Comment for planning application 21/02893/REM

Application Number	<input type="text" value="21/02893/REM"/>
Location	<input type="text" value="Os Parcel 4300 North Of Shortlands And South Of High Rock Hook Norton Road Sibford Ferris"/>
Proposal	<input type="text" value="Approval of reserved matters pursuant to condition 1 of planning permission 18/01894/OUT for details of layout, appearance, scale, landscaping, access and parking for 25 dwellings"/>
Case Officer	<input type="text" value="Nathanael Stock"/>

Organisation Name	<input type="text" value="Stewart Roussel"/>
Address	<input type="text" value="Bramley House,Stewarts Court,Sibford Ferris,Banbury,OX15 5QX"/>
Type of Comment	<input type="text" value="Objection"/>
Type	<input type="text" value="neighbour"/>

Drawing Title:  
Plot 15  
Proposed Plans and  
Elevations

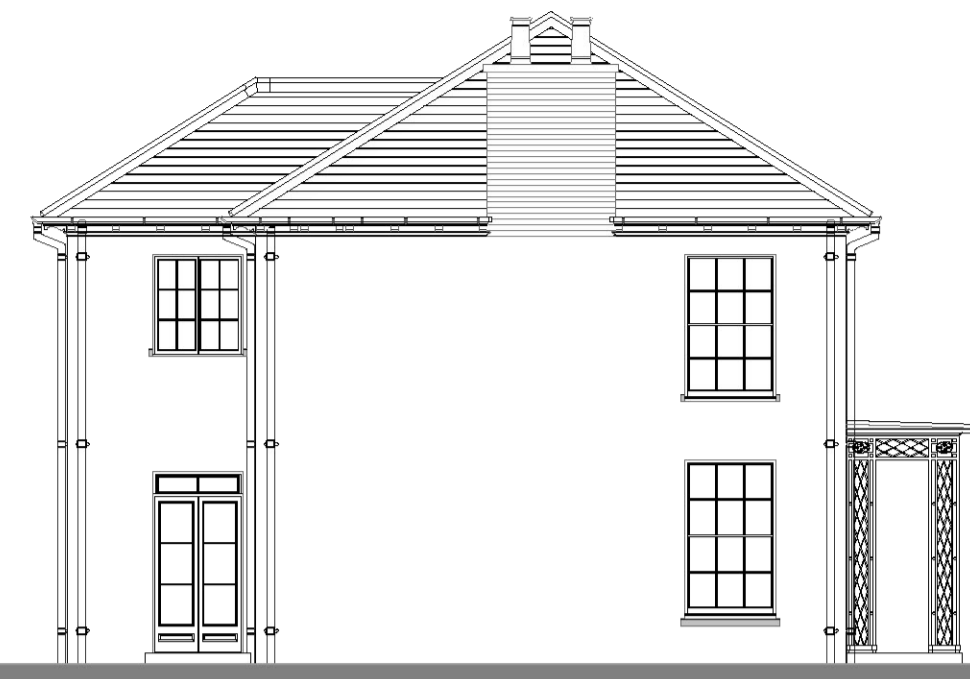
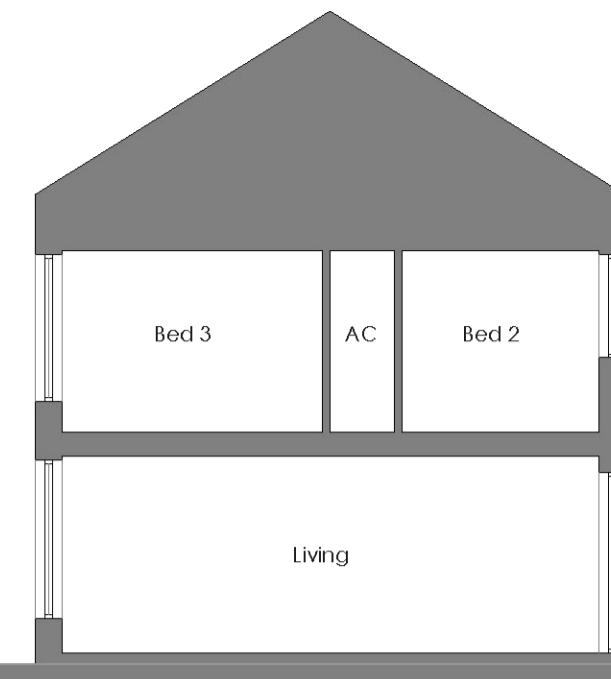
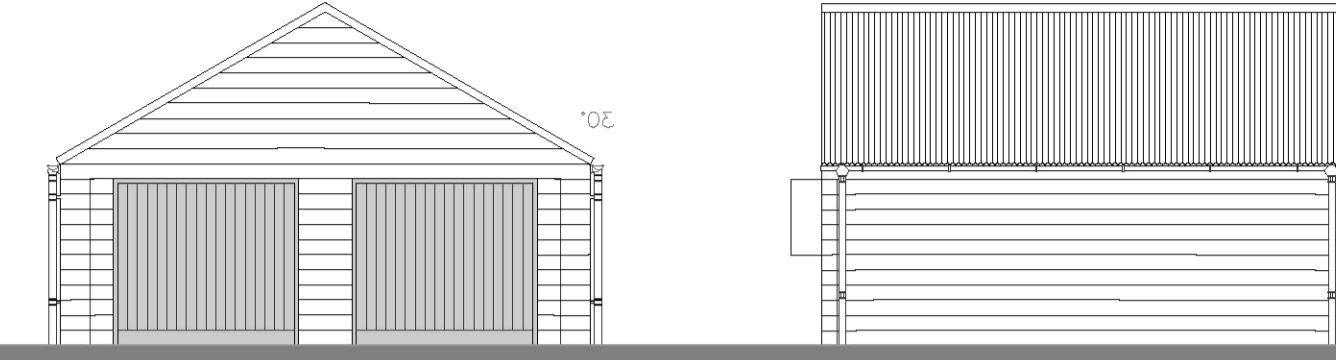
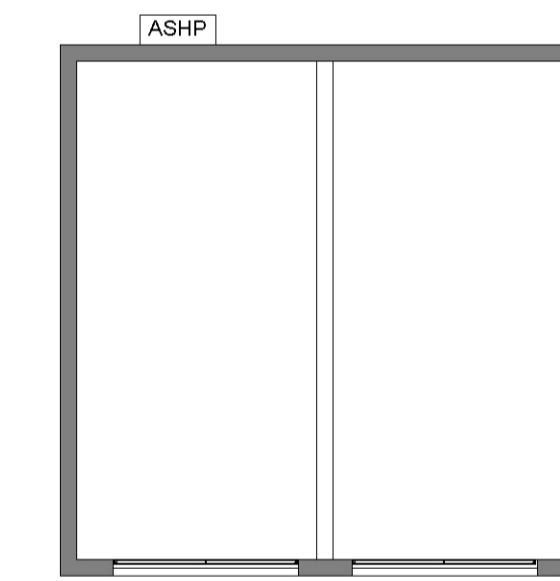
21/02893/REM - Os Parcel 4300 North Of Shortlands And South Of High Rock Hook Norton Road Sibford Ferris 1. The design and access statement document and Site plans 3699101-M, 3699117-E and 3699100- in fact all the documents are submitted on incorrect Google map views and omit Bramley house in the village that was constructed more than 3 years ago and sits between High Rock and Butwick House. Please see the site plan and the updated google map and we trust that Gade homes will amend their documents. We would like it noted that these documents could also be referred to in relation to any future planning applications and therefore need to be corrected. We have emailed the correct google map to CDC planning to Nathaniel Stock. 2. We have concerns over Sewerage. Please see the letter below from Severn Trent to the case officer. Has a sewer modeling assessment been done? Our village sewer is in a steep valley that cannot easily be accessed or enlarged. What has been done to determine if capital improvements are required? We also note condition 8 and even though we can see some work towards including an attenuation area (originally the appeal officer asked for SUDS), we cannot yet see evidence that our sewer can manage the discharge rates and exactly what those maybe? "To determine the maximum pump rate that could be accommodated within the existing network without worsening the existing sewer performance in rainfall events." Our Ref: 2019011819929 Severn Trent Re: Application No. 18/01894/OUT Site Address : Parcel 4300 North Of Shortlands And South Of High Rock Hook Norton Road Sibford Ferris With reference to the above planning application the Company's observations regarding sewerage are as follows. "Foul is proposed to discharge into the public combined water sewer. As a pumped solution is being proposed for foul for this site a sewer modelling assessment will be required, this is to determine what impact the generated flows from this site will have on the network and to determine the maximum pump rate that could be accommodated within the existing network without worsening the existing sewer performance in rainfall events. Severn Trent may need to undertake a more comprehensive study of the catchment to determine if capital improvements are required. If Severn Trent needs to undertake capital improvements, a reasonable amount of time will need to be determined to allow these works to be completed before any additional flows are connected." We trust that you will receive the full report and sewer modelling assessment in full before approving this planning application. We may only see the reality of the situation once the homes are completed. 3. Ridge Heights are a concern. We question whether homes that are 9.7 m on high land will actually be in keeping with the ridge heights in the area? Where will ground level be in relation to the ridge heights? 4.37 The proposed dwellings are 2 storeys, reflecting the scale, height and built form within the immediate context and the wider village context. 4.38 The proposed heights of houses vary between 7.3m and 9.7m. We are attaching a topographical survey of surrounding properties. High Rock (directly adjacent to the site is 6.4m, Bramley House is 8.15 and Cotswold House number 1 is 7.81m.) How can 9.7 m on land that is higher than High Rock be in keeping with the surrounding area? We also question the necessity of garages on plots 15 and 16 having garages that are 1.5 stories instead of being single story.
